# ENG-SF19009-V3-FDR-redlines.pdf Markup Summary

**Subject:** EPC ENG Review  
**Page Index:** 1  
**Date:** 5/13/2020 11:12:17 AM  
**Author:** dsdrice  
**Color:** ■  
**Layer:**  
**Space:**  
**Page Label:** 1

RETREAT AT TIMBERIDGE FILING NO. 1
CONSTRUCTION PLANS
CHECK STRUCTURES AND
SELECTIVE BANK STABILIZATION
DESIGNED BY MAW SCALE DATE 04-05-19
DRAWN BY MAW (H) 1" = 30' SHEET 27 OF 35
CHECKED BY (V) 1" = N/A JOB NO. 1185.00

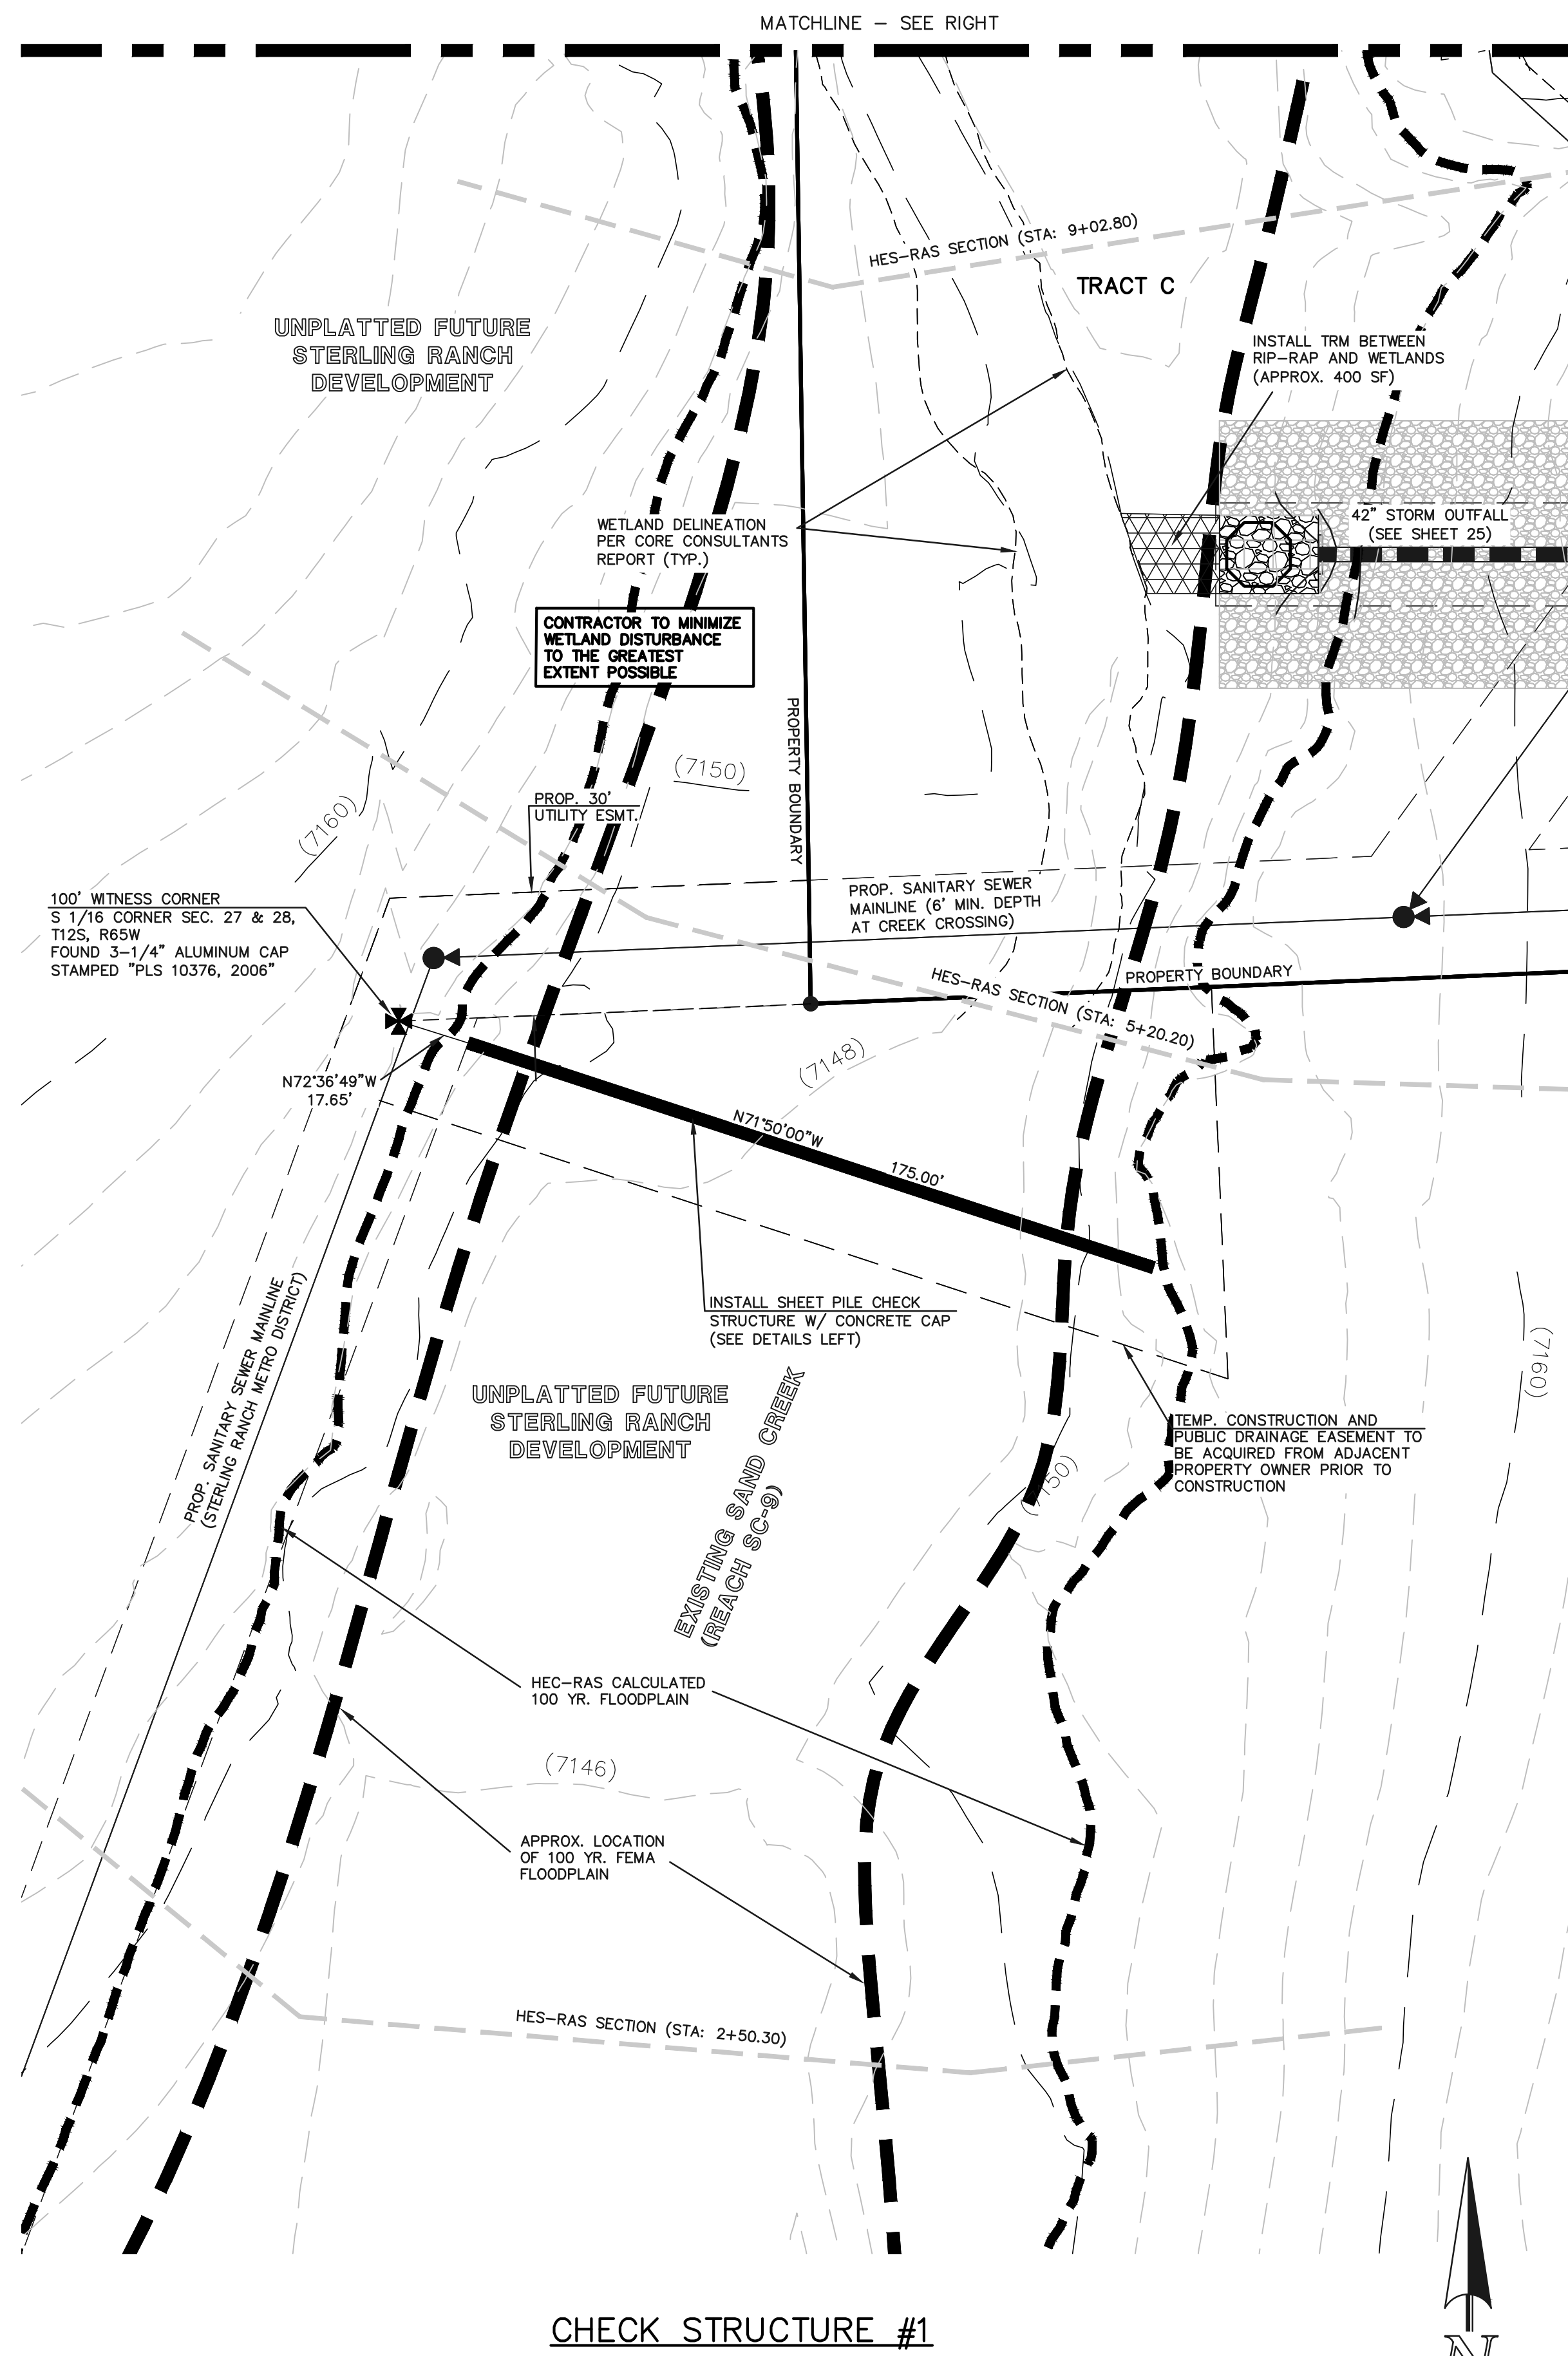
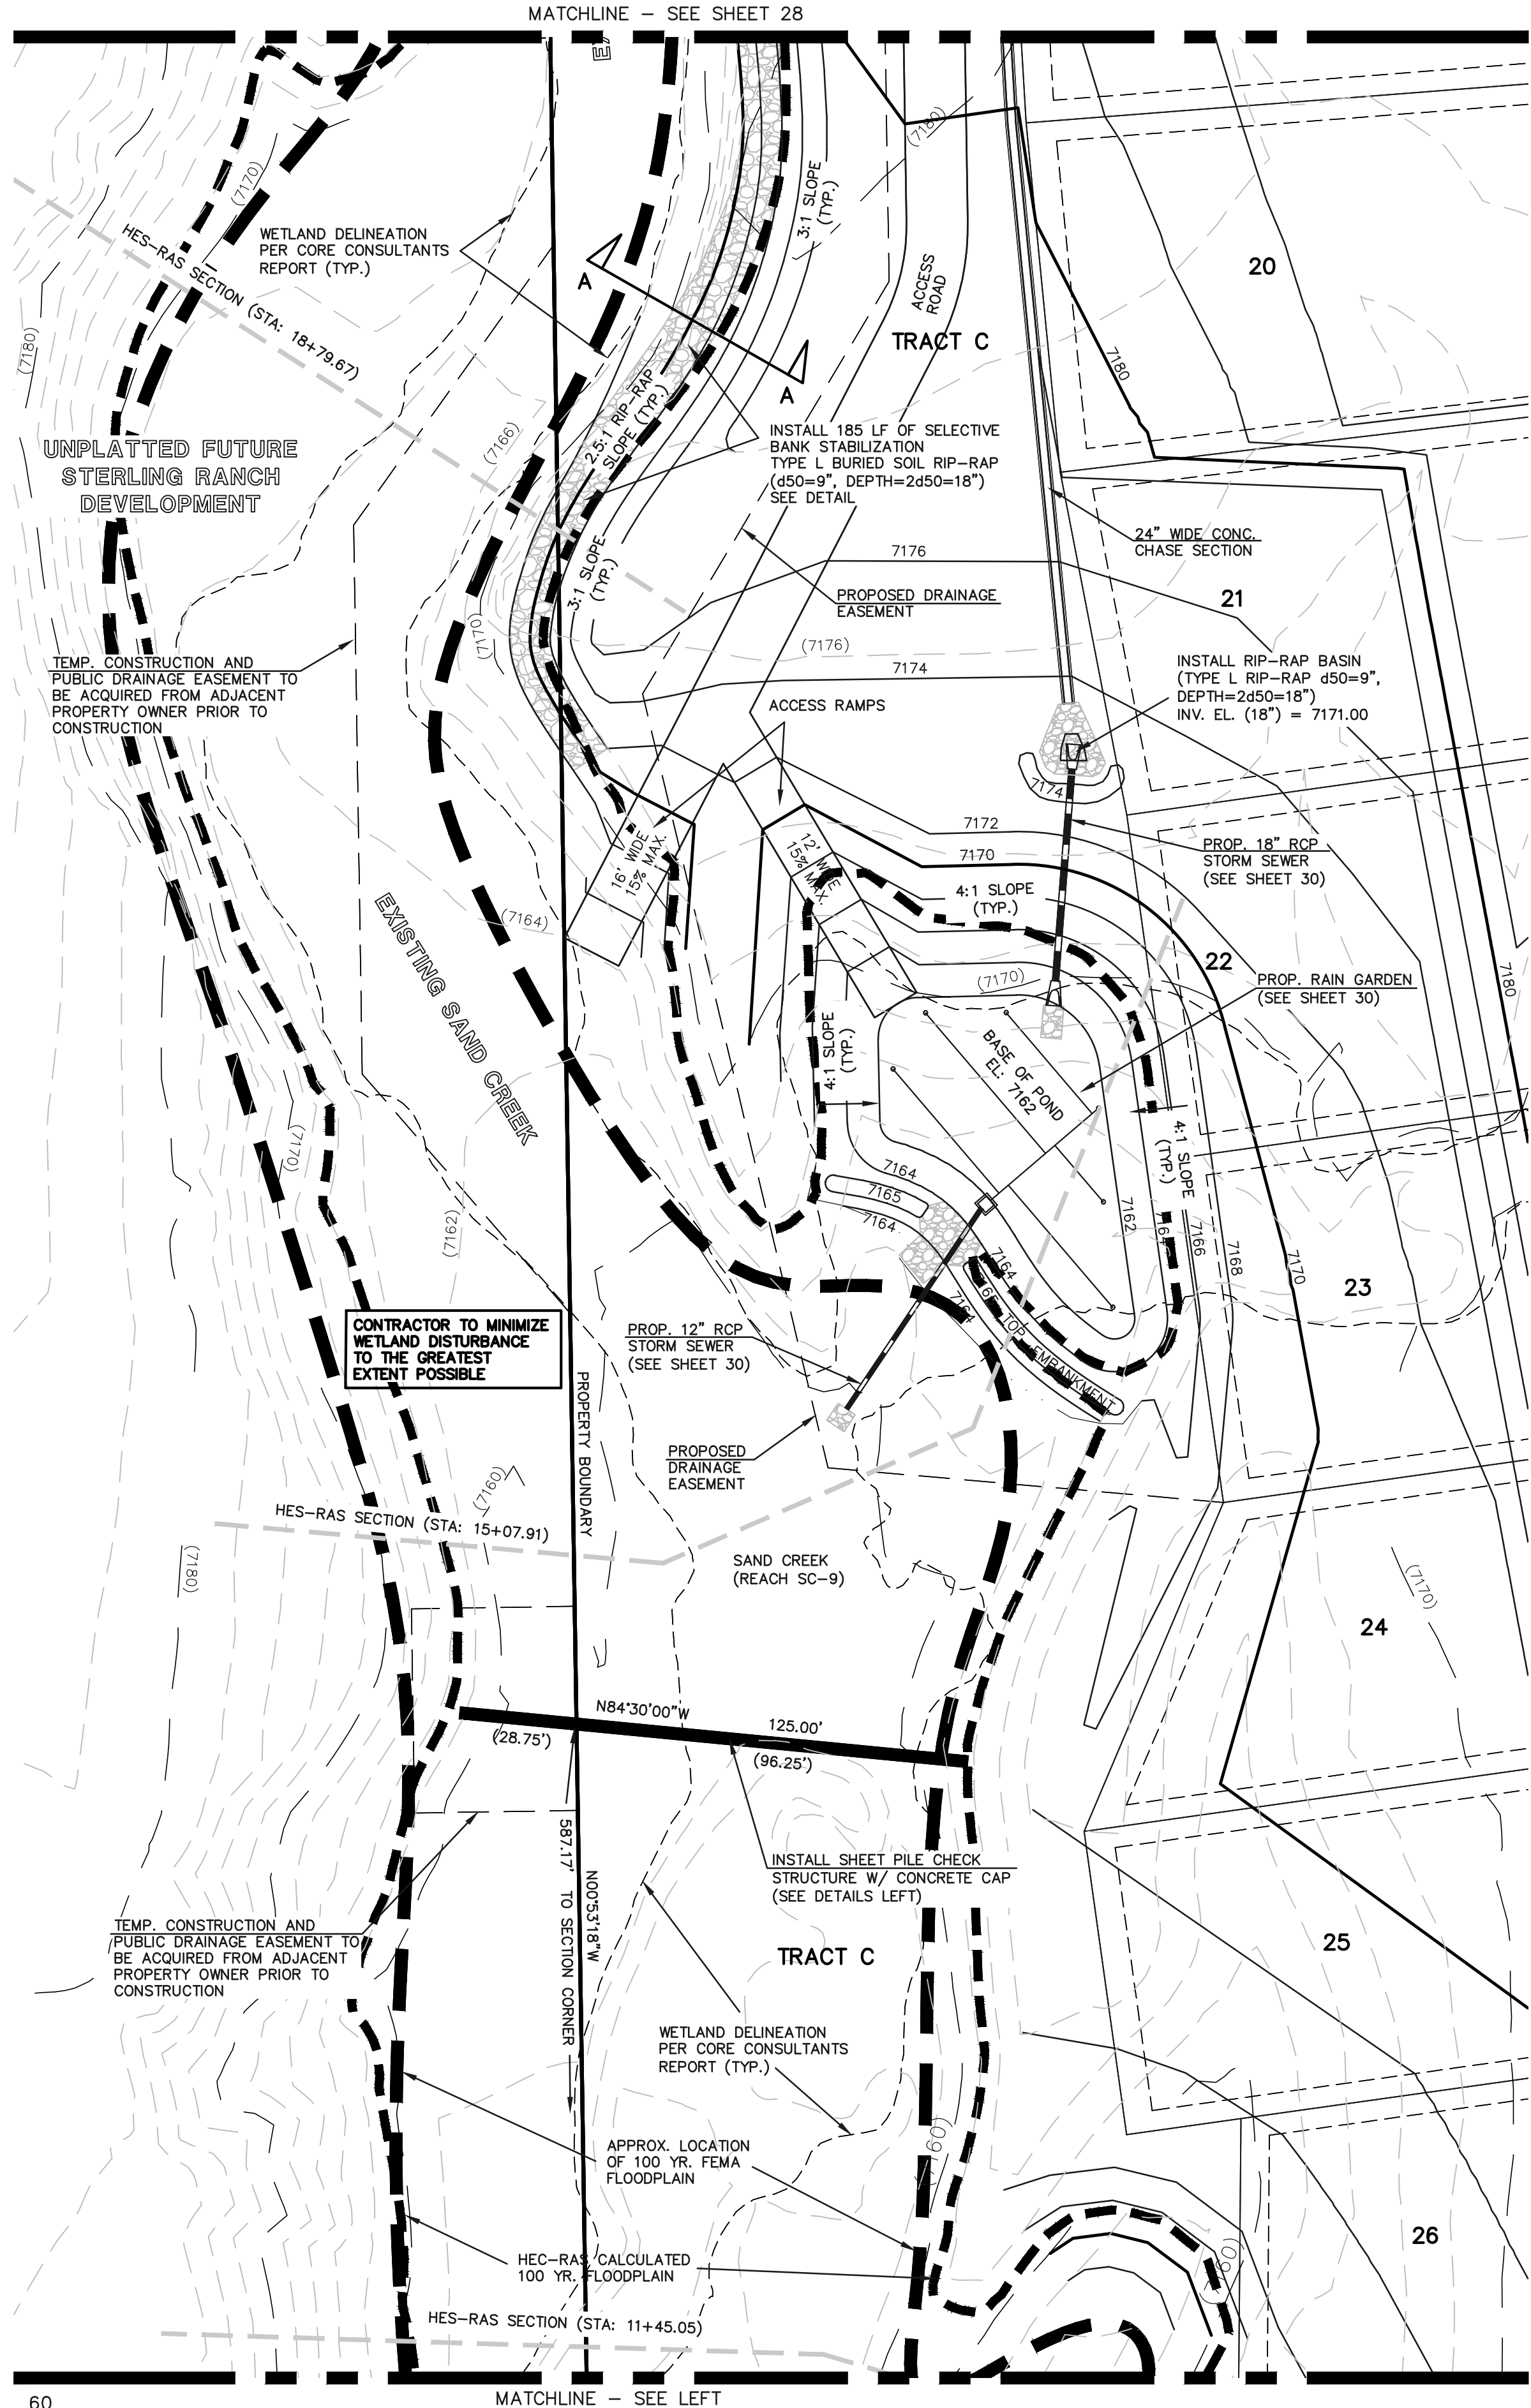
It appears that bank stabilization should be provided here adjacent to proposed lots.
